Kirklees Council
Planning and Development Service
PO Box 1720
Huddersfield
HD1 9EL

Date: 25-Oct-2024
Our Ref: 2024/90237

**Discharge of conditions 3 (construction environmental management plan), 4 (public right of way), 5 (retaining walls), 6 (Phase II Report), 7 (Remediation Strategy), 9 (Remediation Validation Report) and 18 (Japanese Knotweed) of previous permission 2021/92062 for erection of 9 dwellings and associated works adjacent, Britannia Road, Golcar, Huddersfield, HD3 4QB
Application Number: 2024/90237**

03 BOUNDARY TREATMENT - ADJACENT BUILDING SECTION SCALE 1:20

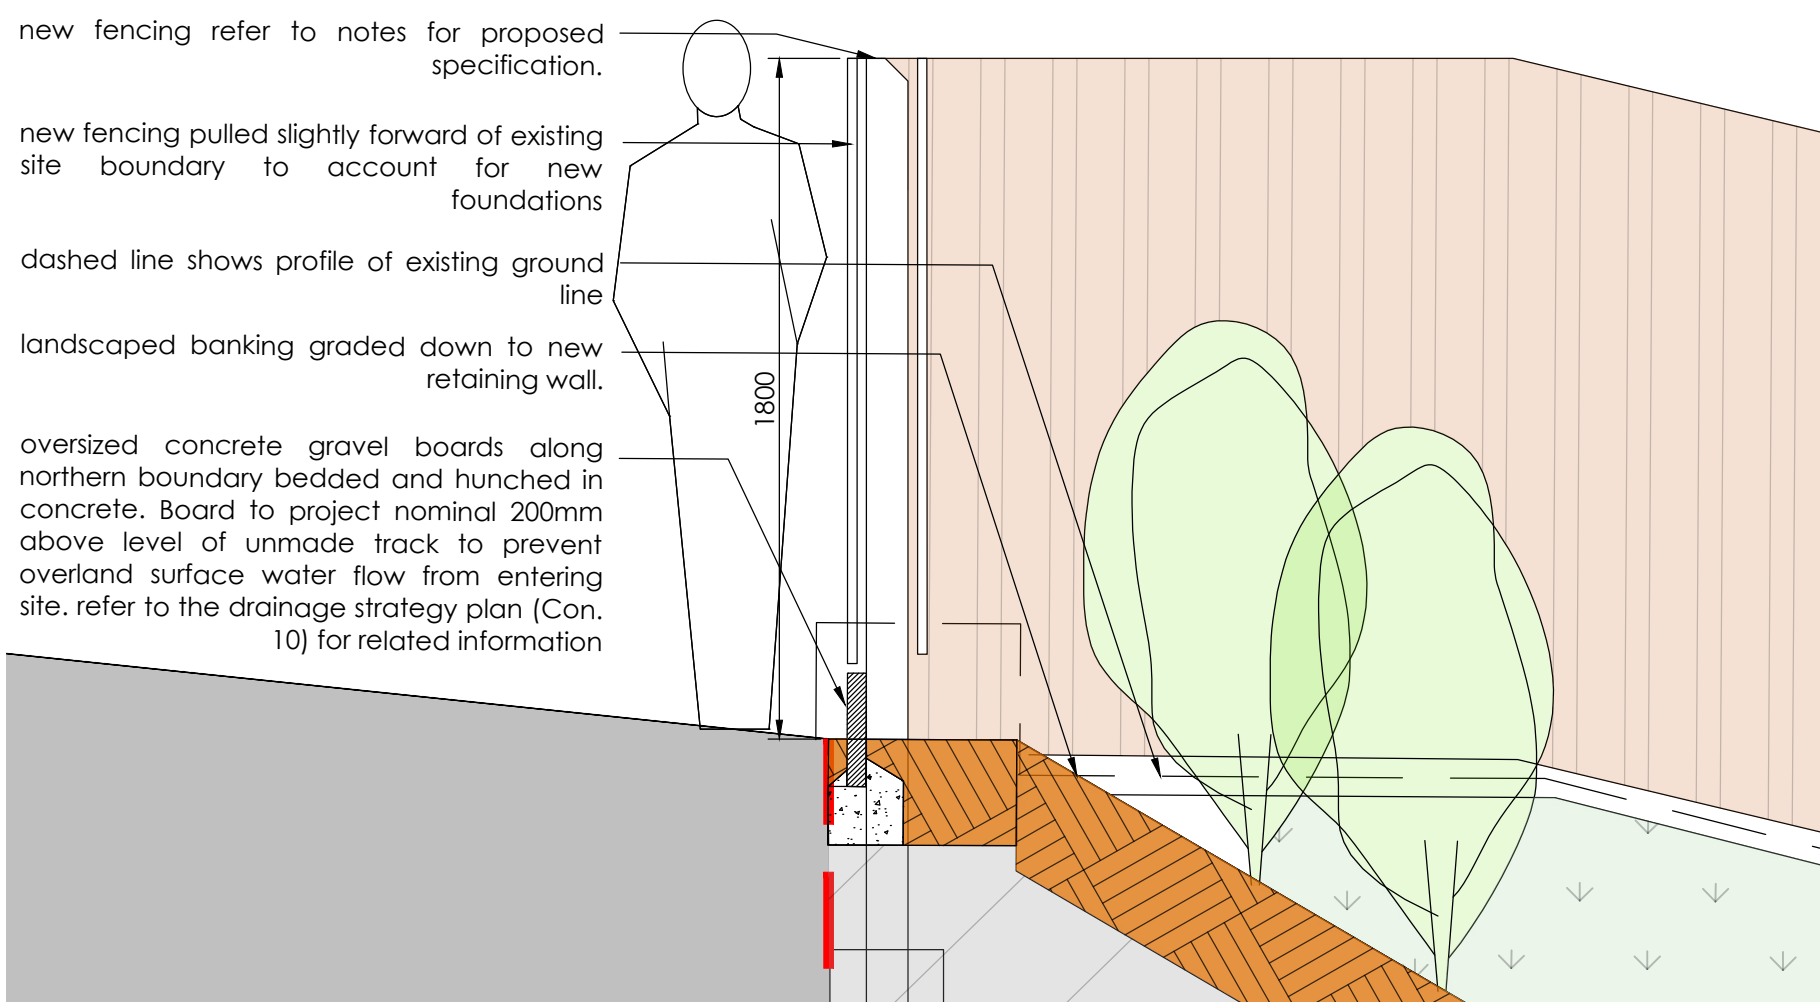
This condition requires technical and fully dimensioned sectional plans to detail the proposed engineering and retaining works, at or near the new and existing highway, to allow officers to assess that the works would be undertaken safely and without prejudicing the road network. No such adequate details have been provided.

Further to the above, the plans which have been provided indicate changes to the proposed design and method of retention / engineering works within the site from the approved plans. It is outside the scope of the Discharge of Condition process to make such amendments to the approved plans.

For the avoidance of doubt, no approval is hereby issued pursuant to condition 5.
